Greater Dublin Drainage Project Addendum

Addendum Planning Report

Uisce Éireann

October 2023

Drawing file: GDD Planning Drawings / 32102902-2148_P01  Proposed Culvert at Mayne River Crossing - WwTP Access Road (Sheet 1 of 2).pdf

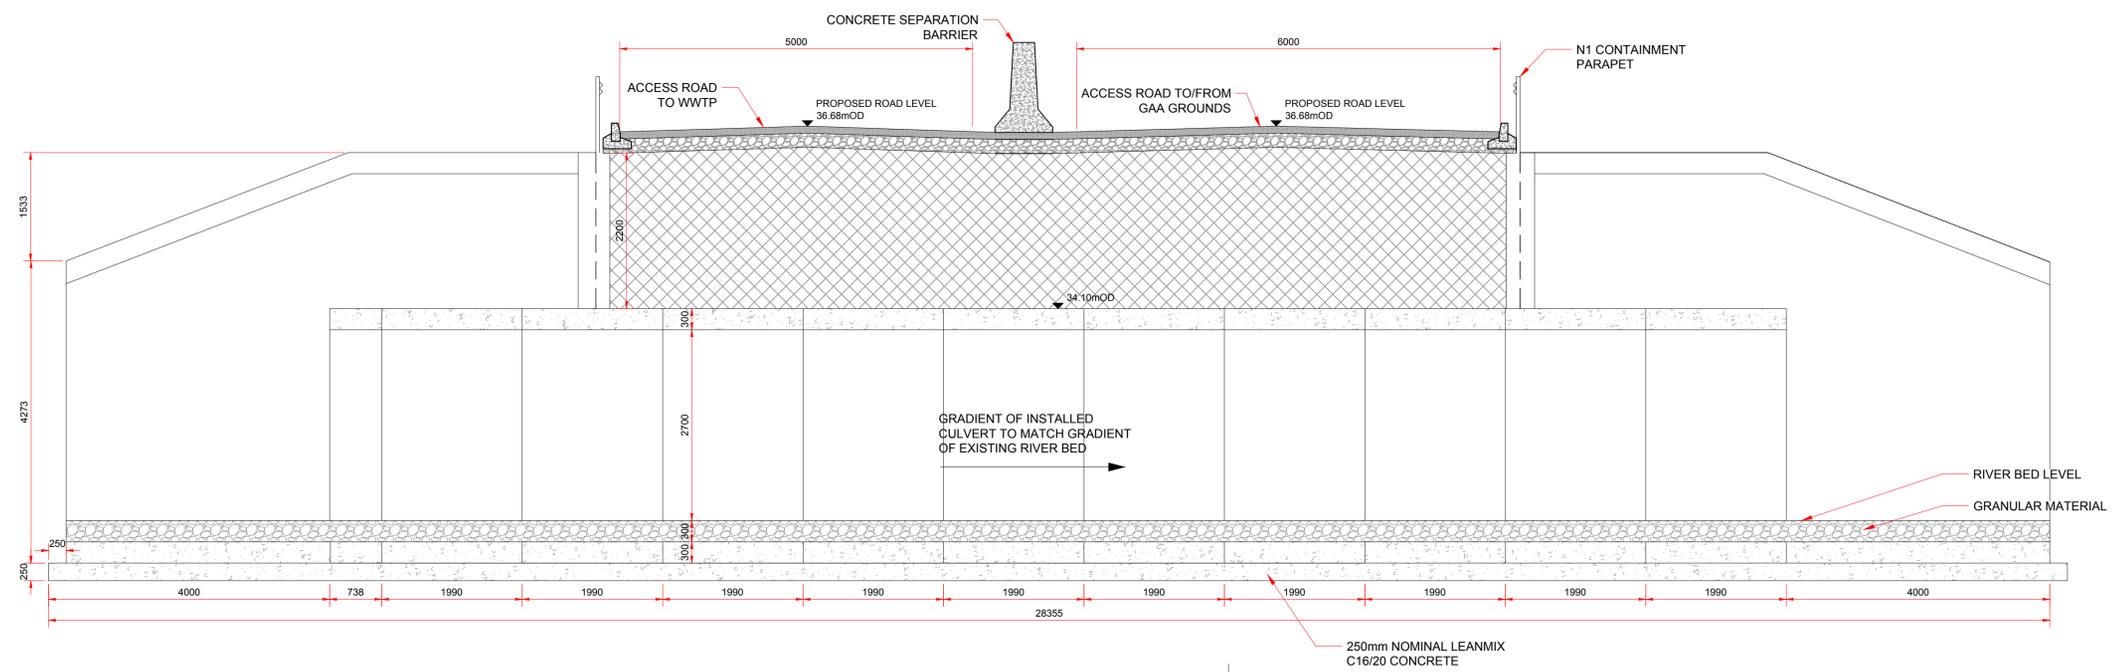
There will also be an extension to the River Mayne Culvert proposed under the access road to the proposed WwTP off the R139 Road, to cater for the full width of the future north-south link road.

'the developer shall increase the width of the culvert at the crossing of the River Mayne as part of the Clonsaugh site entrance, to cater for the full width of the future north south link road'.

The River Mayne Culvert will be extended by 4m, from the original 21m presented in the 2018 planning application, to 25m, in order to meet the requirements of Condition 13(c). This extension will result in the Proposed Project extending outside the original proposed CPO boundary at this point. Notwithstanding, the River Mayne Culvert extension will remain within the planning redline boundary of the Proposed Project and has therefore been considered to comprise an update to the Proposed Project. This River Mayne Culvert extension is presented in Planning Drawing Number 32102902-2148 and 32102902-2149.
